Re: Please submit additional documents - 520 Capisic Street

Job Name PEAK ROOFS

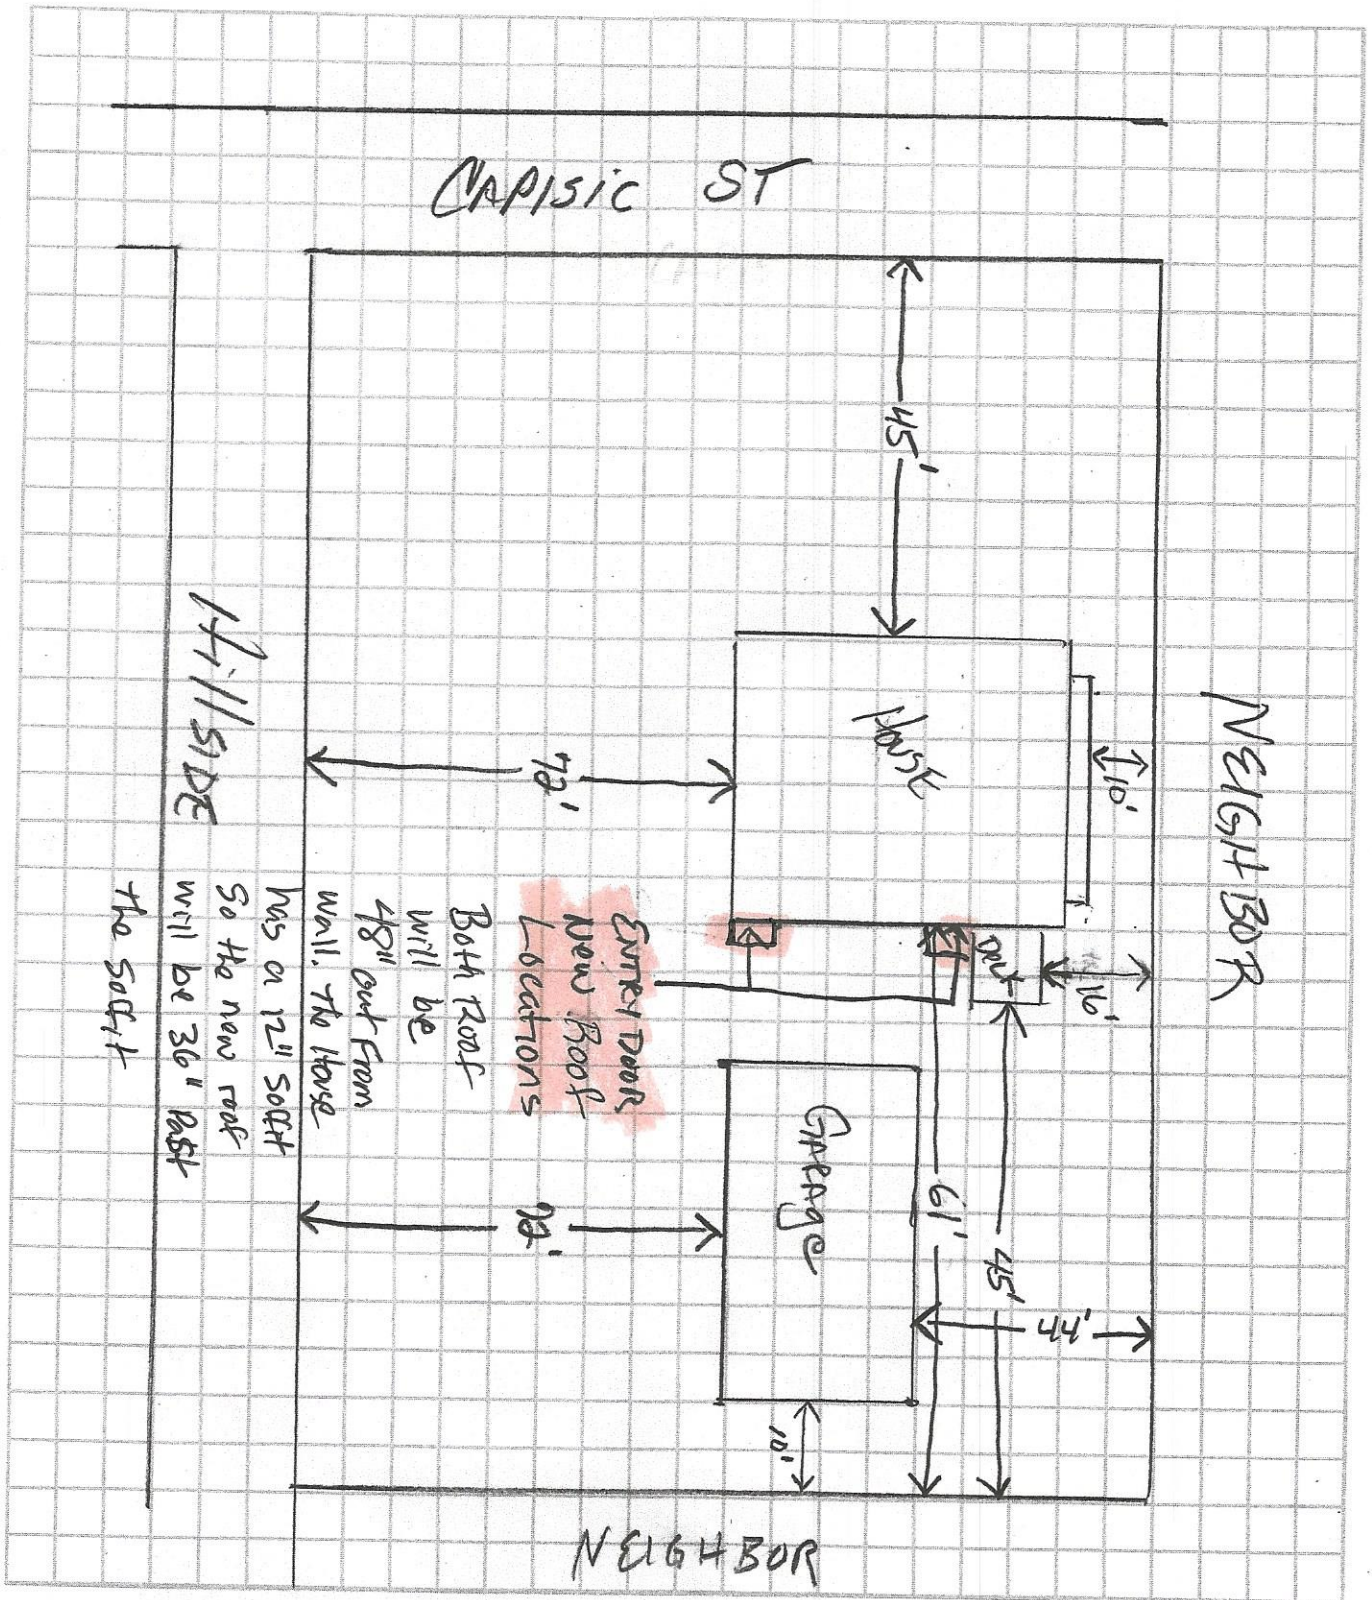
1. The General Building Permit that you submitted is blank. Would you please send us a completed permit application? Please write the dimensions of the two new roof structures on your building permit.
2. Please submit a plot plan that includes the dimensions of the new roof structures on the footprint including dimensions showing how far out the new structures extend from existing roof.
3. Submit a simple front elevation sketch of the whole structure and where on the structure the new roof additions will be located.
4. Please specify the material of the support beam and support beam dimensions.
5. Submit a sketch showing how the support beam/bracket will be attached to the house. Are you attaching it to plywood, a stud?
6. Specify whether the doors are existing doors.

Q-2 see revised plot plan with explanations
